**Consultation Response from KC,
Highways Development Management****2024/90476 Moss Edge Farm, Moss Edge Road, Holmbridge, Holmfirth, HD9 2SD****Demolition of Pole Barn and erection of one dwelling****Date Responded: 13-5-2024.****Responding Officer: Mark Berry.****Responding Ref: 3-25-1.**

Proposed Site Layout
Scale 1:200

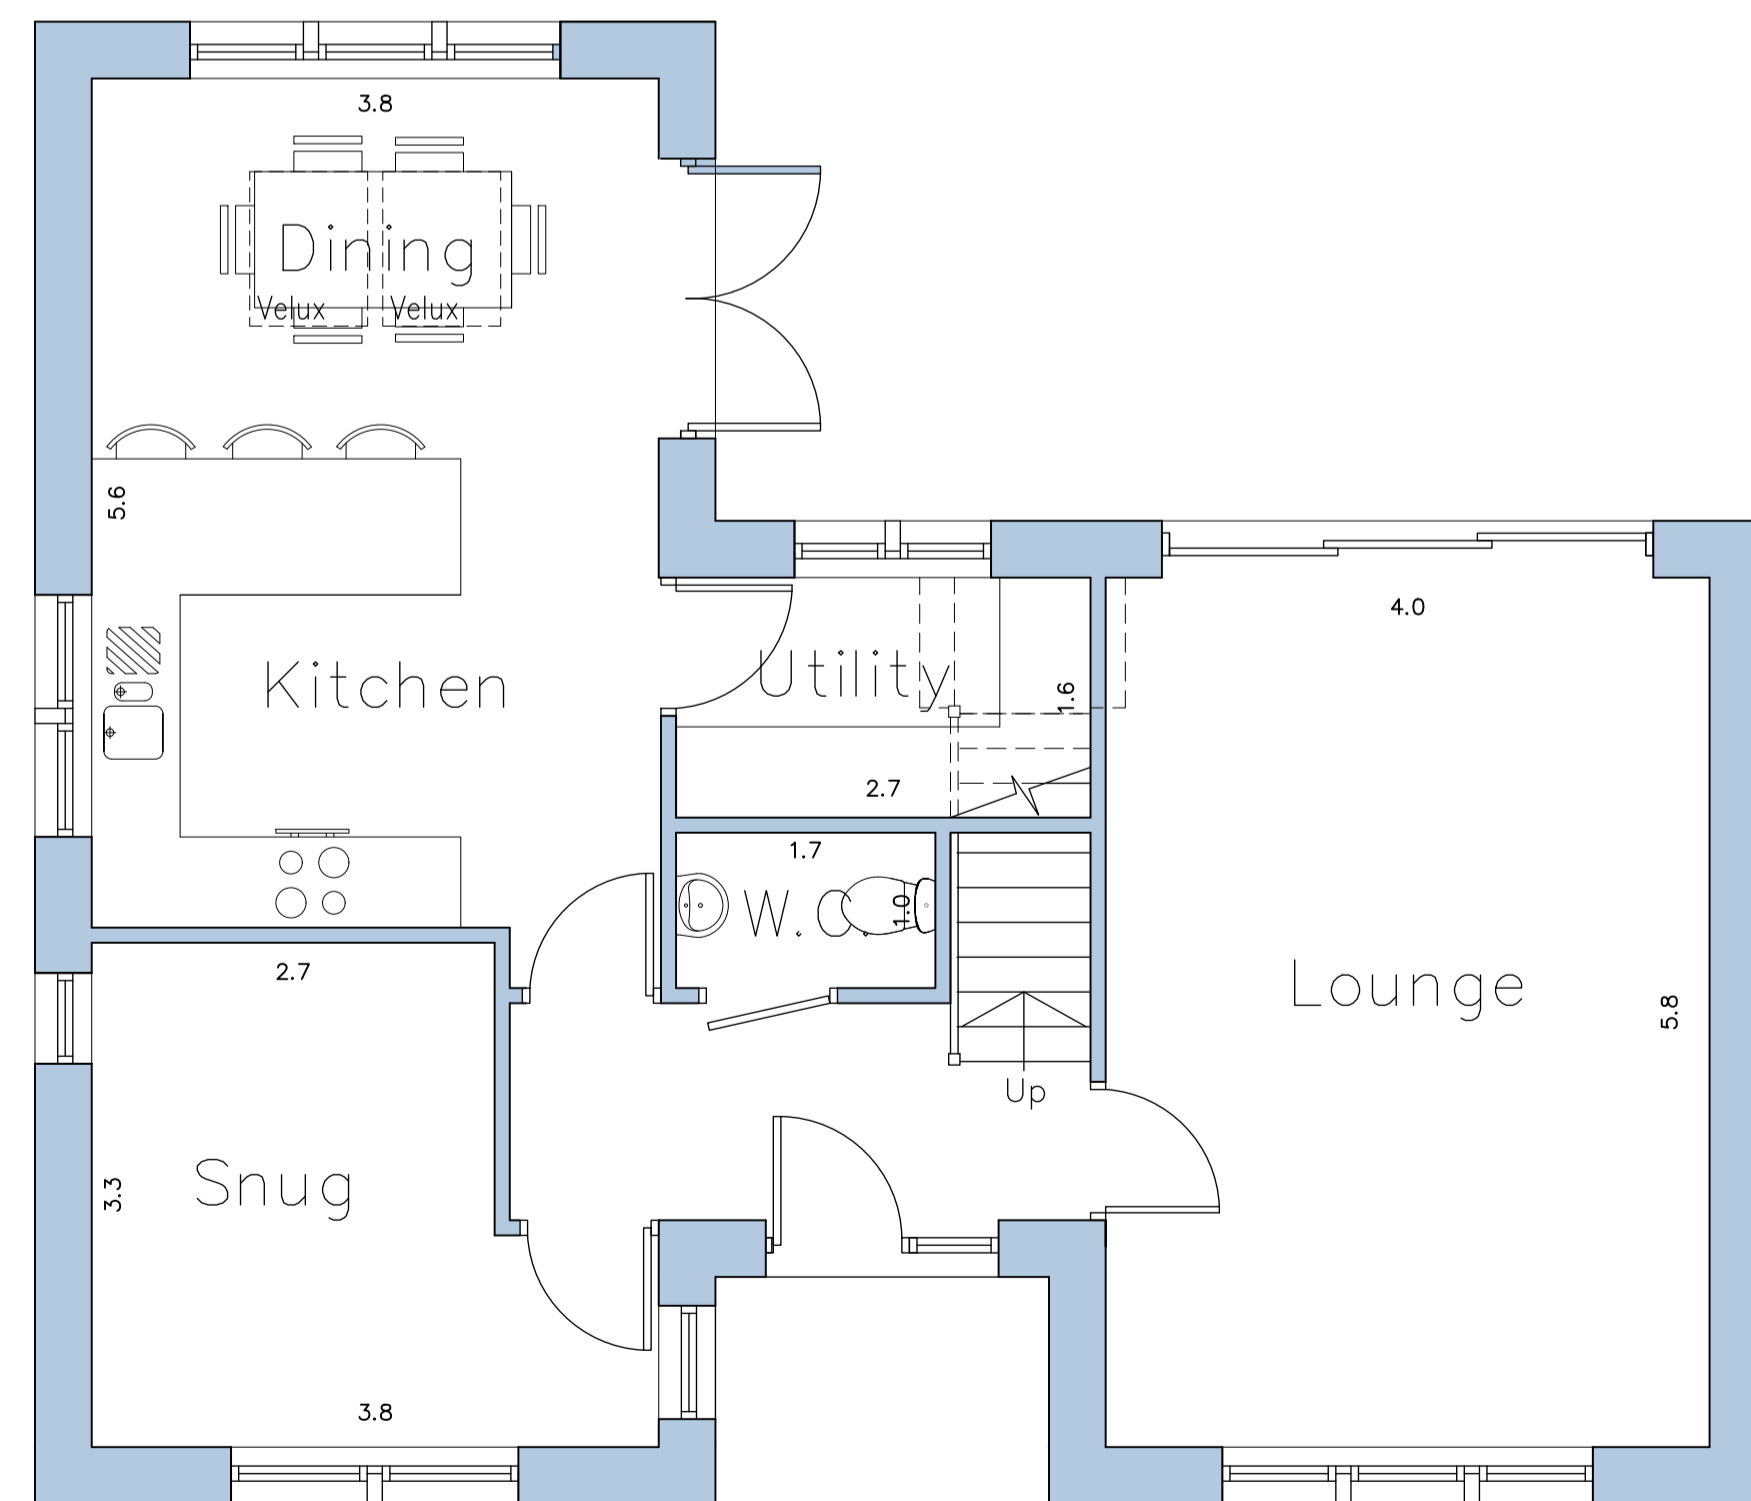
This proposal shows a proposed new 3 bed-roomed dwelling adjacent to the 3 dwelling that were granted change of use by 2023/CLASS Q/91342 prior notification. Two dedicated off-street parking spaces are shown to the side of the proposed dwelling.

Given the previous approval for 3 dwellings, and that improvements have been undertaken including the provision of passing places Highways Development Management have on balance no objection to these proposals.
